**KIRKLEES METROPOLITAN COUNCIL
INVESTMENT & REGENERATION SERVICE**

DELEGATED DECISION TO DETERMINE PLANNING APPLICATIONS

Reference No: 2018/62/90112/E

Description: Erection of single storey rear extension

PROPOSED DETAILS

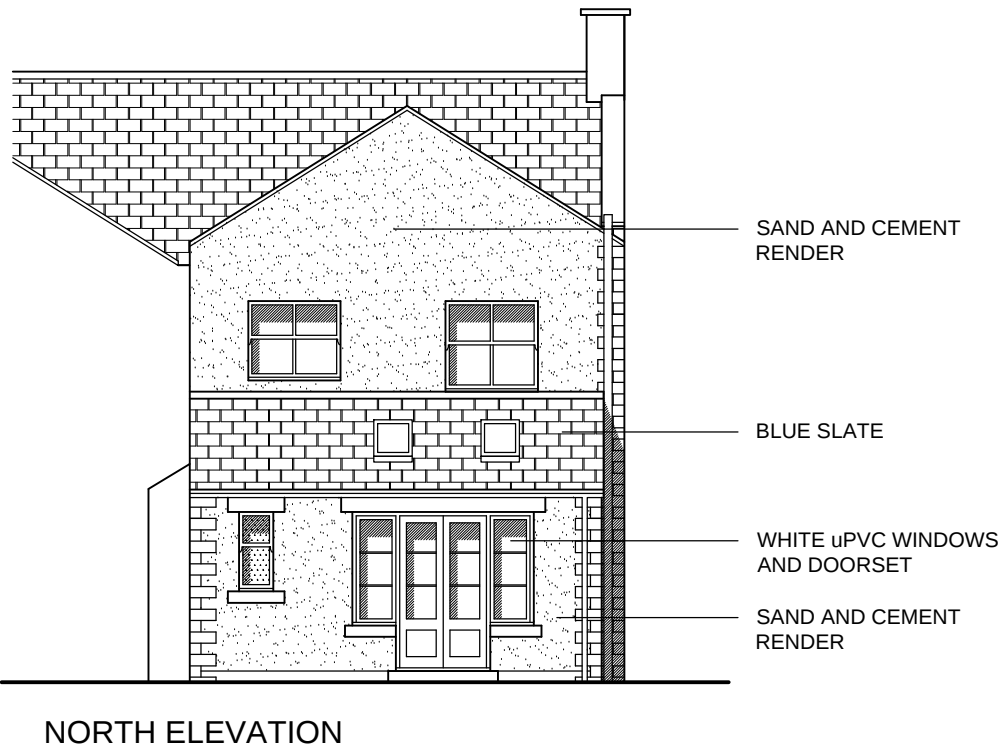
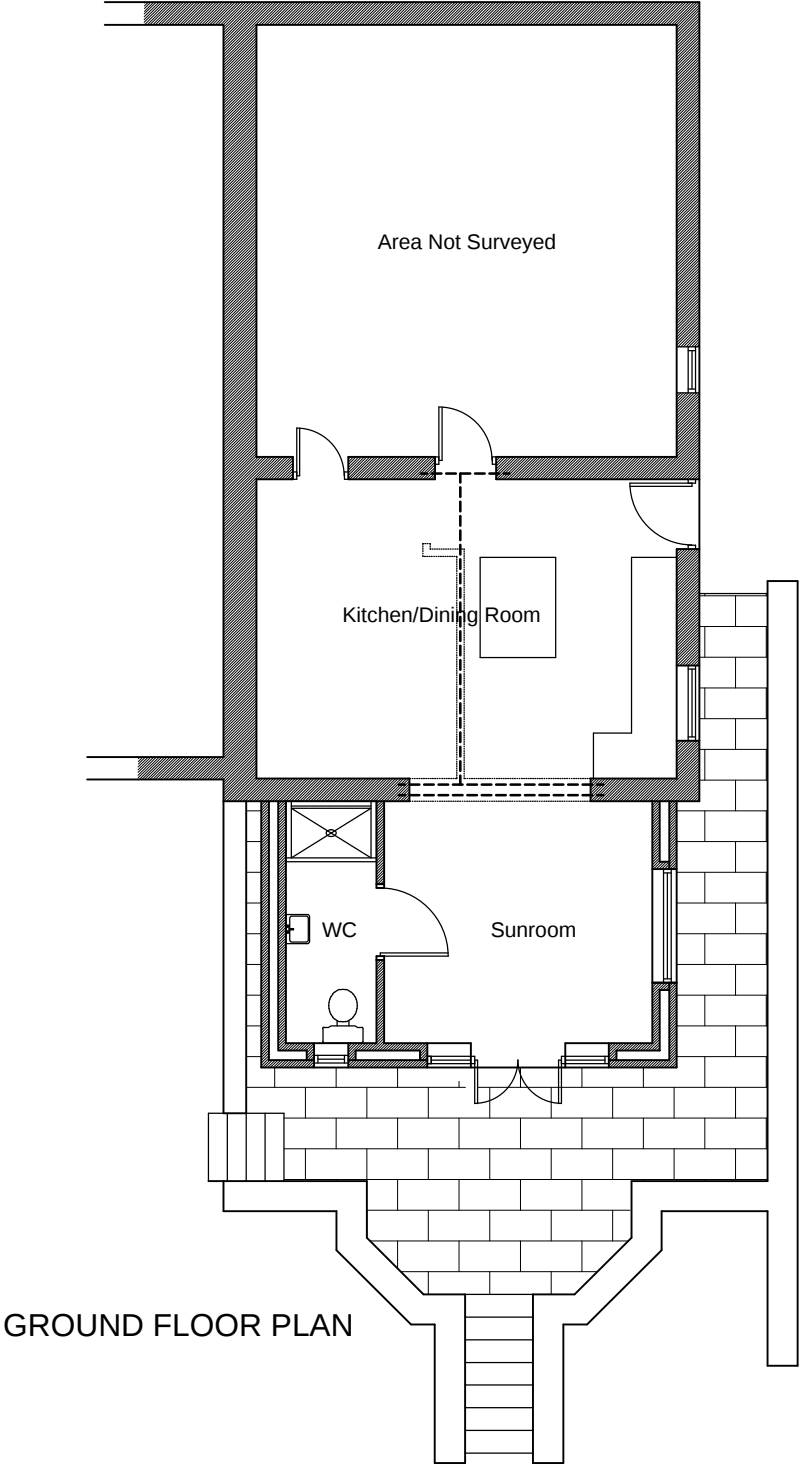
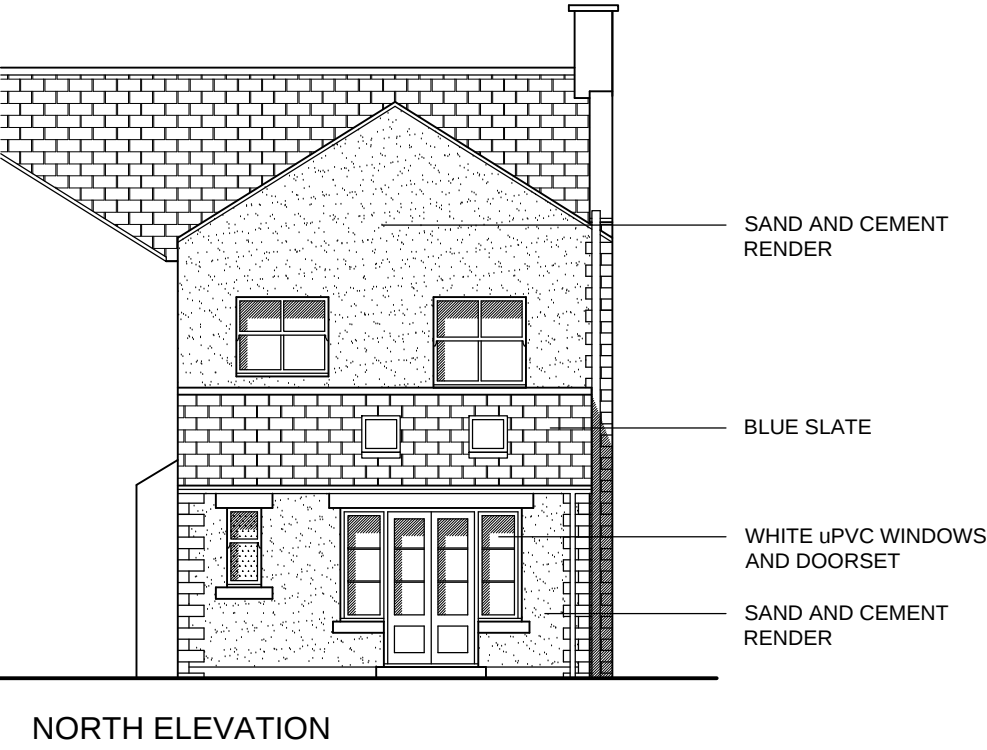
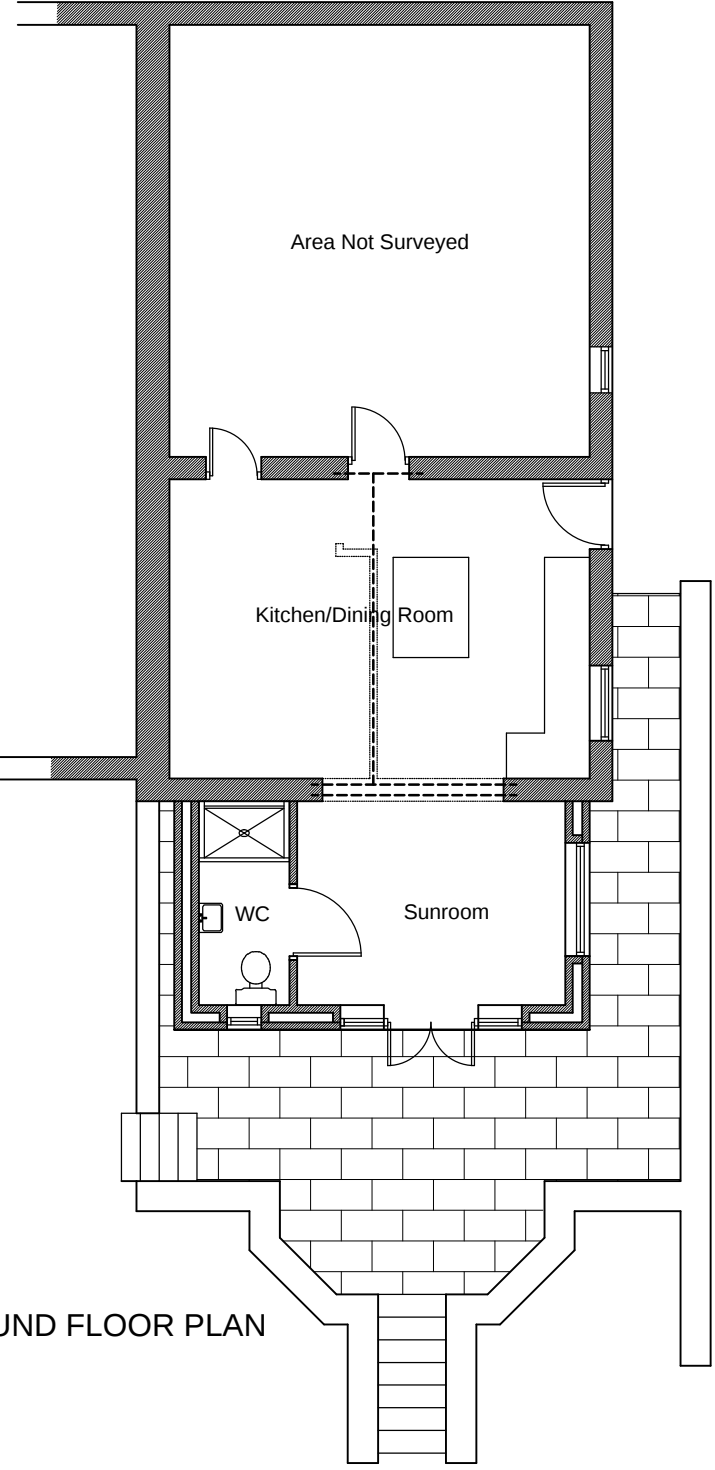
The extension as shown in the initially submitted drawing would project from the rear elevation of the host property by 3.5m, contrary to policy BE14 of the UDP. There are considered to be no site specific factors in this case that could mitigate the impact of the extension at the proposed scale. Therefore, the agent has been requested to amend the scheme to comply with the relevant policy in the UDP.

A revised plan has been received on 20-Feb-2018, which has incorporated the amendment requested by the officer. No further consultations are considered necessary in this case because the amended scheme would be materially smaller than the submitted scheme and it would have less of an impact on visual amenity and residential amenity than the submitted scheme. The acceptability of the revised scheme shall be addressed in the following assessment.

The rear extension would project from the external back wall of the existing house by 3m and it would be set back from the external side walls by approximately 0.4m. It would be of reasonable scale relative to the host property and its associated curtilage, complying with the aim of policy BE14 of the UDP. The extension would appear subservient when looked together with existing house.
